APPENDIX H CONSULTATION RESULTS

H.1 OFFICE OF ENVIRONMENT & HERITAGE

RE: SEARs for proposed Sunraysia Solar Farm (SSD 7680)

Sunraysia Solar Farm - HV Easement

Figure 5-1 Environmental features

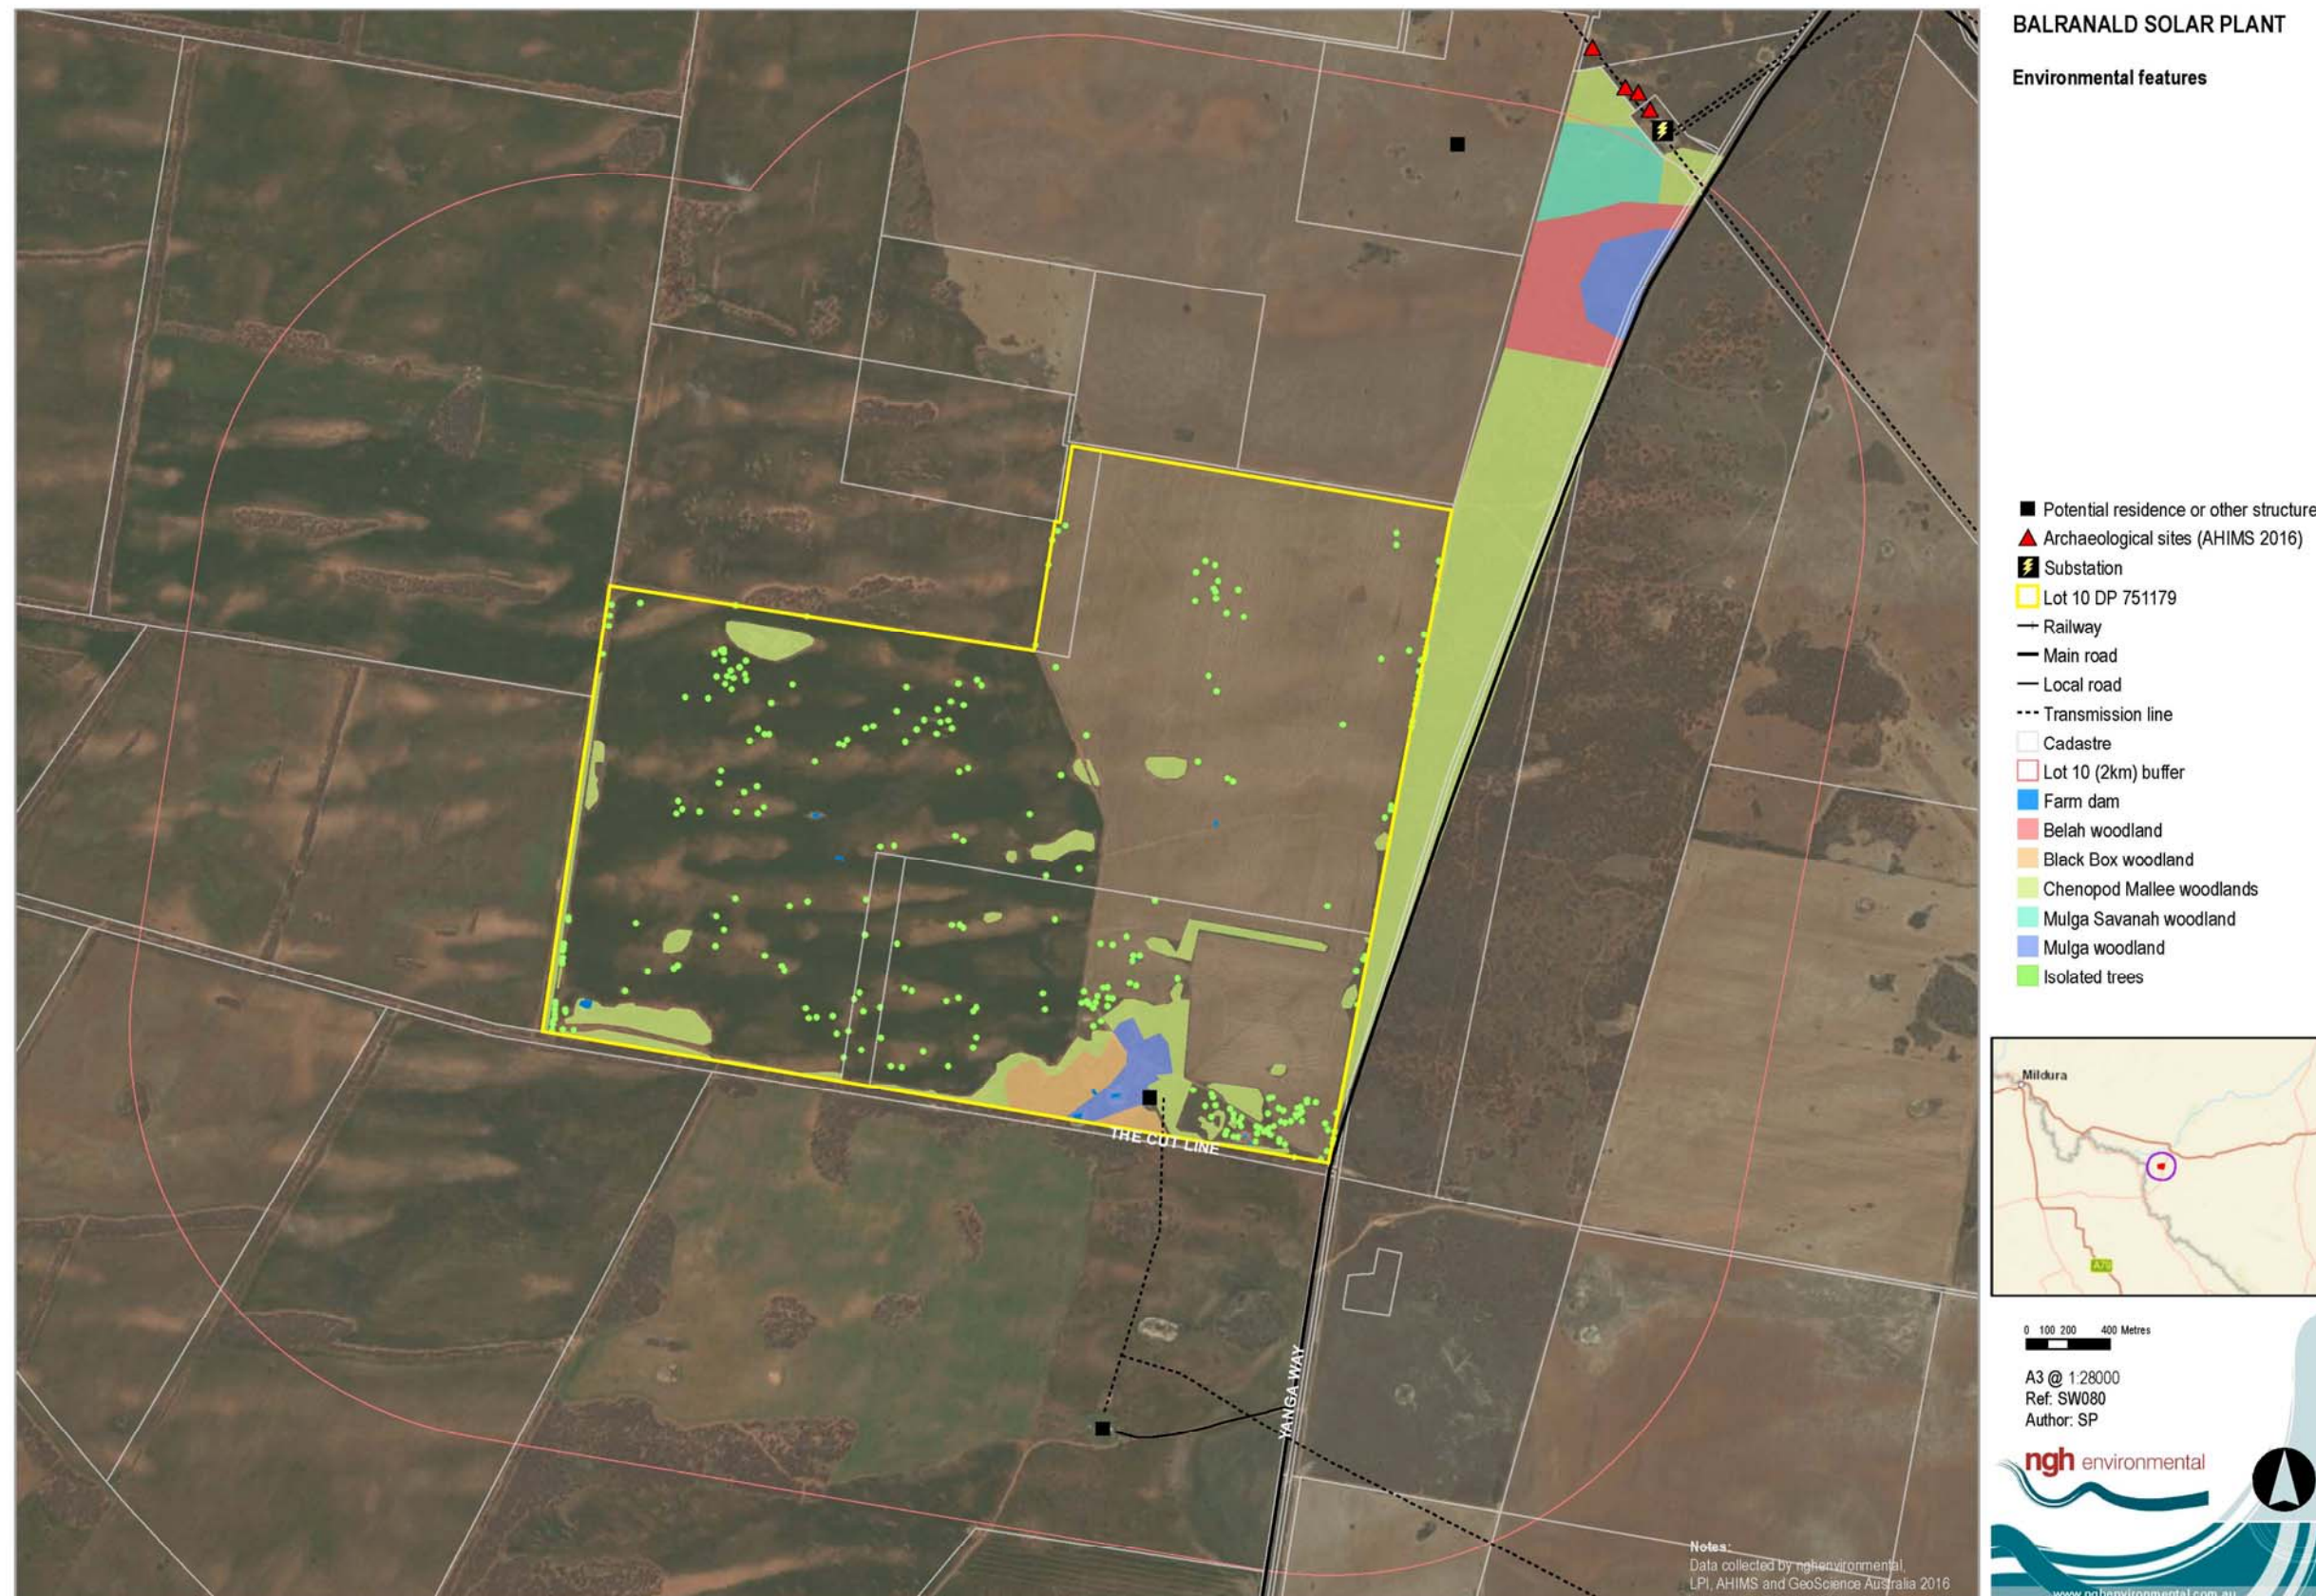
Based on the information provided, the proposed site appears to contain scattered trees with some remnant patches of vegetation. It is important to ascertain whether areas with scattered trees meet the definition of woodland or open woodland communities. Trees in an open woodland may be up to 100 metres apart, and still meet the definition of native vegetation that can be allocated to a NSW Plant Community Type (PCT). PCT boundaries mapped for this assessment must include the understorey and trees. Maps containing separate polygons for trees and understoreys (e.g. Figure 5-1) may not be correct. The categorisation of some vegetation as "Mulga woodland" (Figure 5-1) needs to be considered as this community is not known to occur in this area.
